Consultation Response from KC, Conservation and Design
2020/94336 63, Huddersfield Road, Meltham, Holmfirth, HD9 4AF
Demolition of dwelling (within a Conservation Area)
Date Responded: 12.2.21
Responding Officer: Sue Oakley
Responding Ref:

No 63

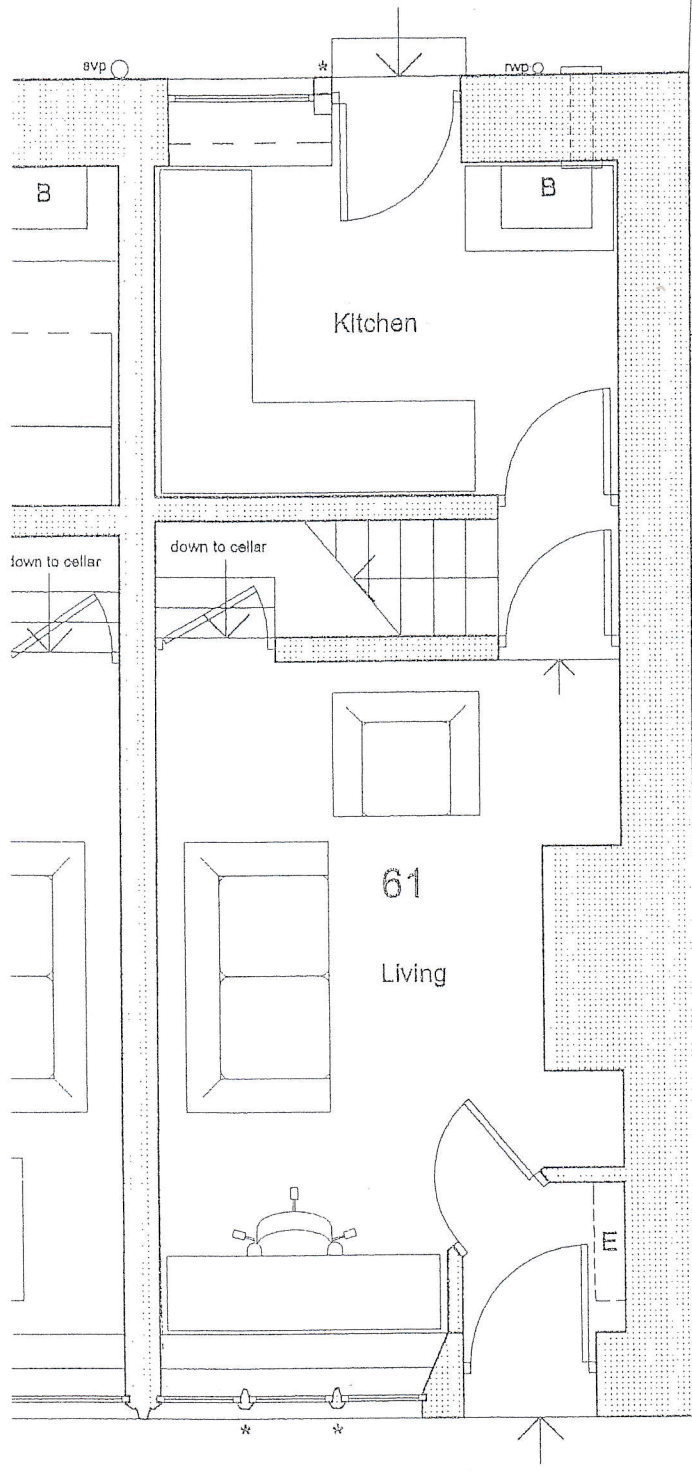
In this case, there is no evidence that the applicant has considered alternative options for the building such as repairing and rebuilding it, and no structural report has been provided to demonstrate that it is beyond repair.

If the gable and chimney are unstable, I have no objections to the unstable sections being recorded and carefully taken down prior to rebuilding like for like, with any recommendations from a qualified structural engineer, such as internal propping, carried out where necessary.

I would suggest that the applicant explores the option of rebuilding this cottage and creating doorways through to the adjacent cottage at 61 Huddersfield Road, which is in the same ownership, to increase the habitable space within this property. A Listed Building Consent application will be required for any alterations to number 61.

I am unable to support this proposal based on the information provided. However, if it is considered acceptable, Listed Building Consent will be required for works to the wall and roof of the listed building at 61 Huddersfield Road. If the evidence shows that the kneelers were originally part of the listed building these should be reinstated.
